LOT 2, STERLING RECYCLING FACILITY

SITE DEVELOPMENT PLAN

PPR2341

SITE DEVELOPMENT PLAN

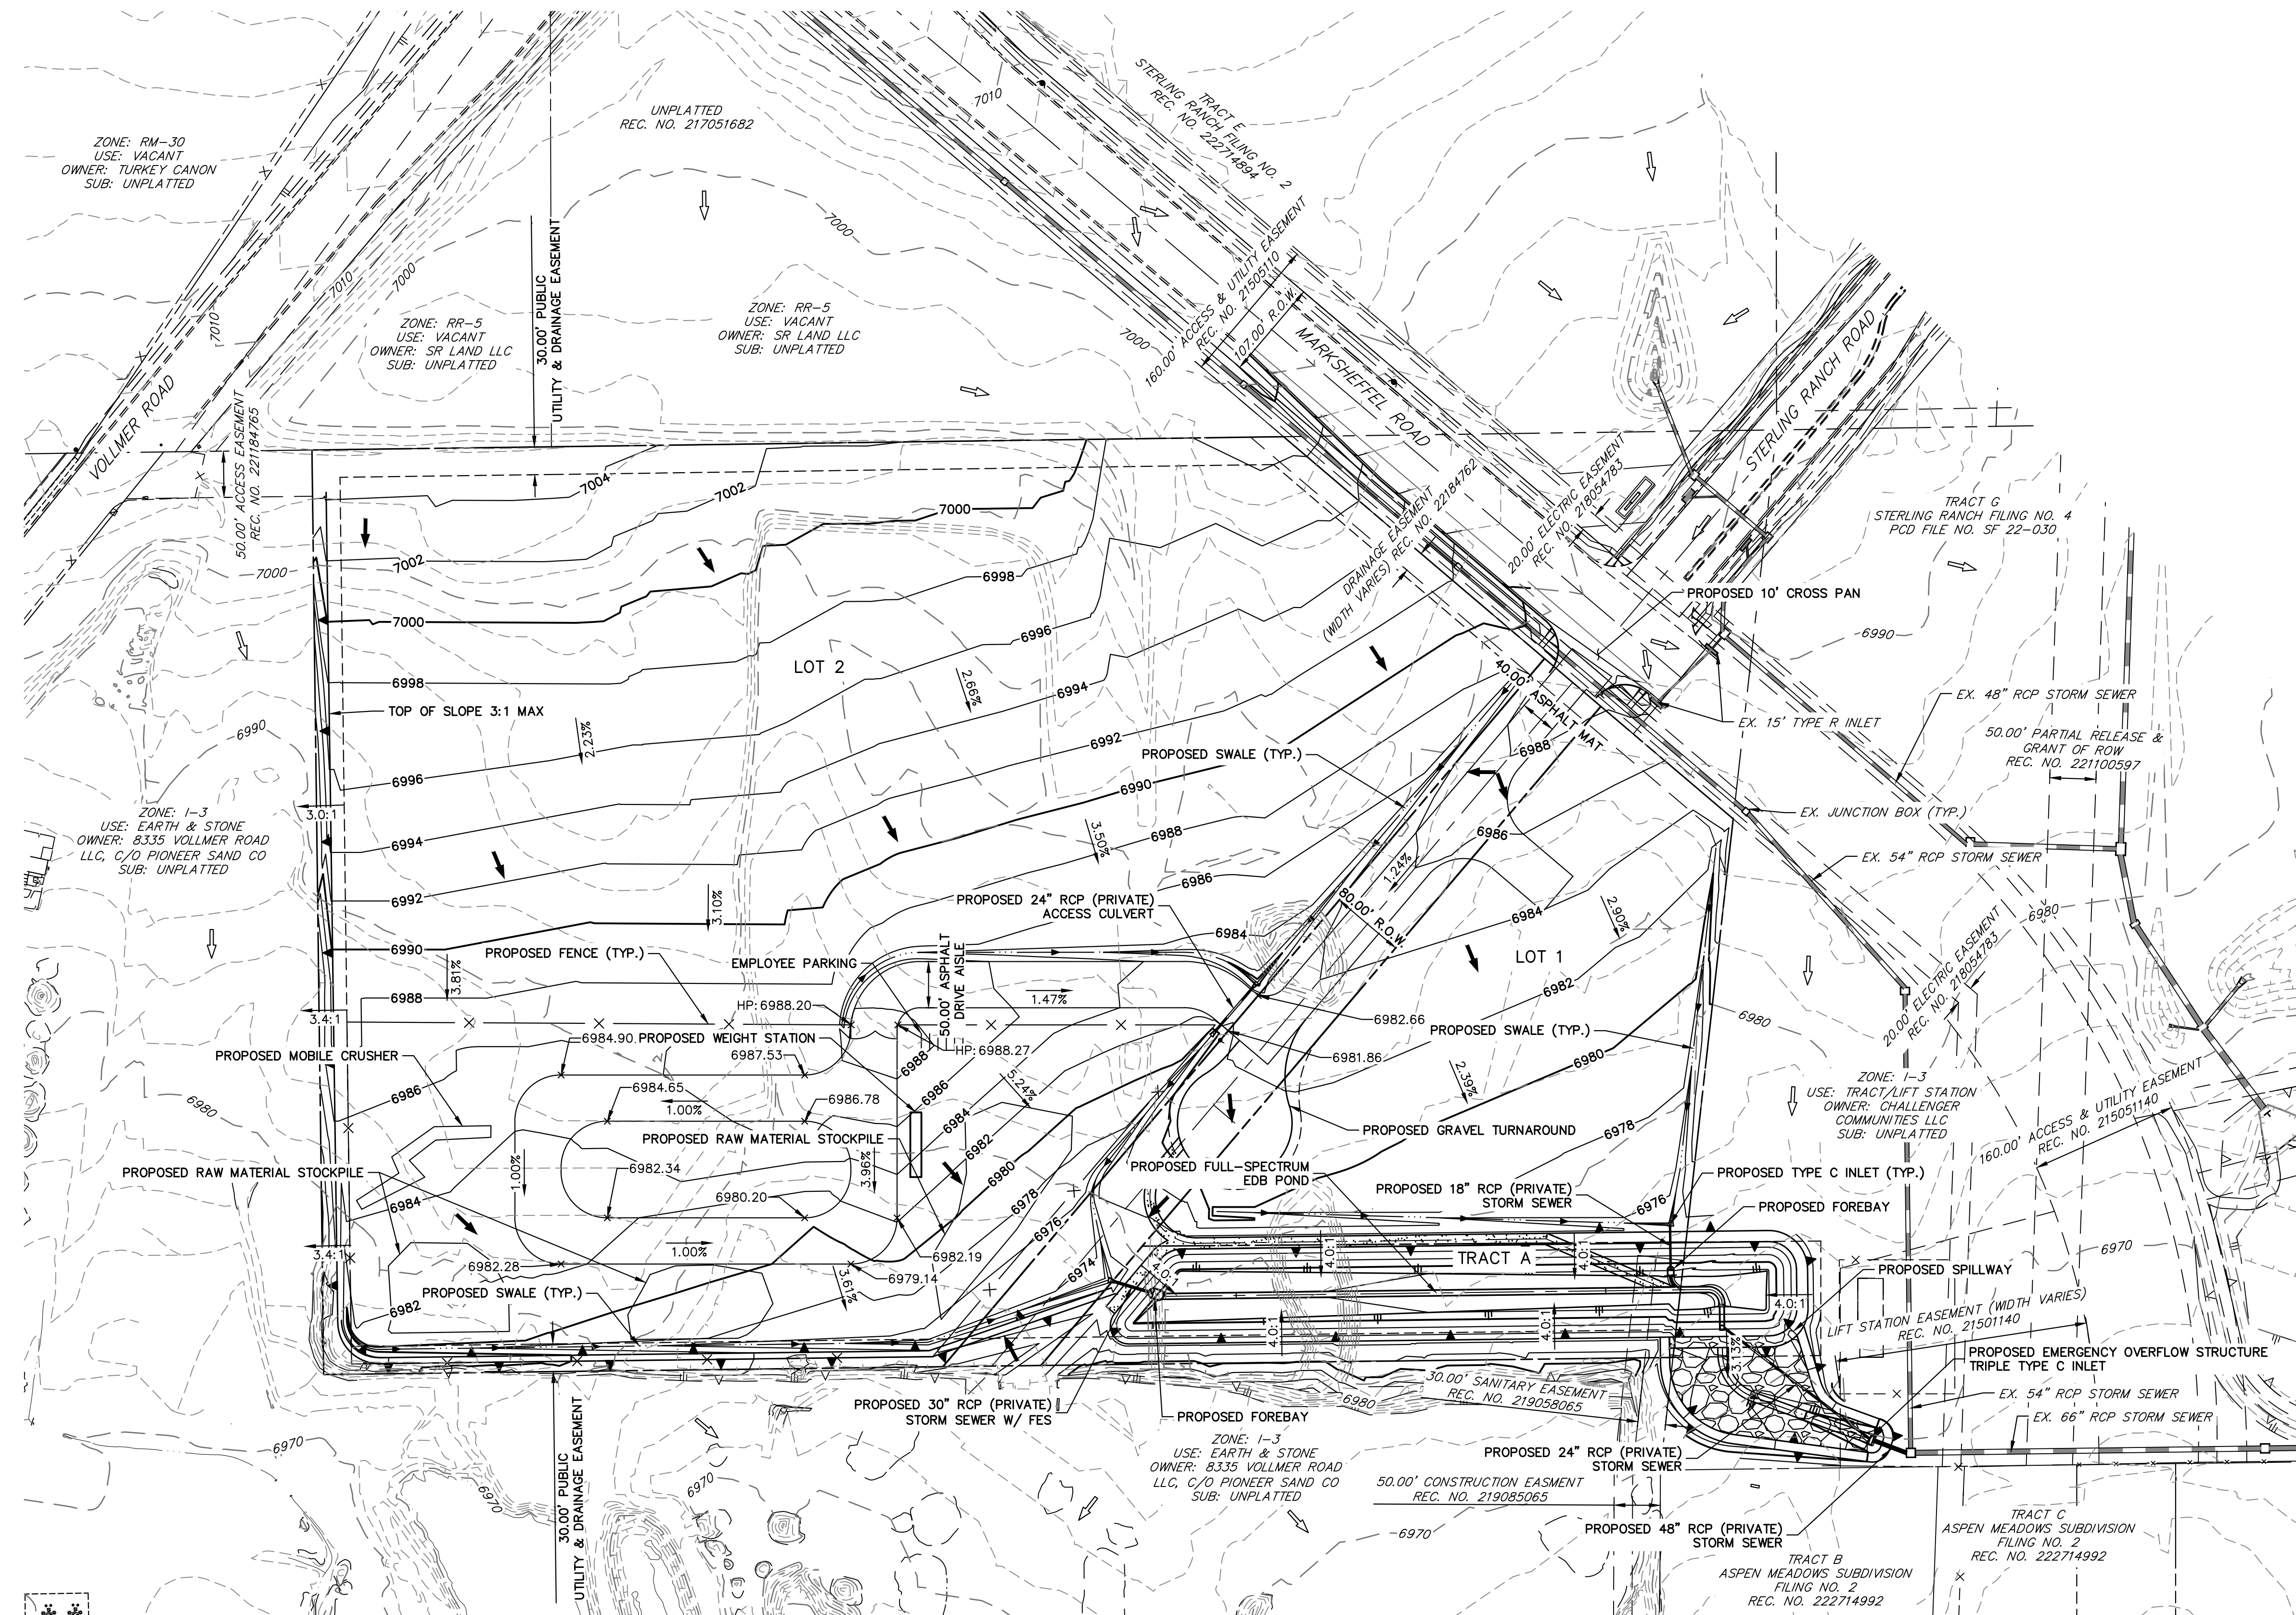
Denote completion or proposed for this pipe. Provide note See comment in the FDR
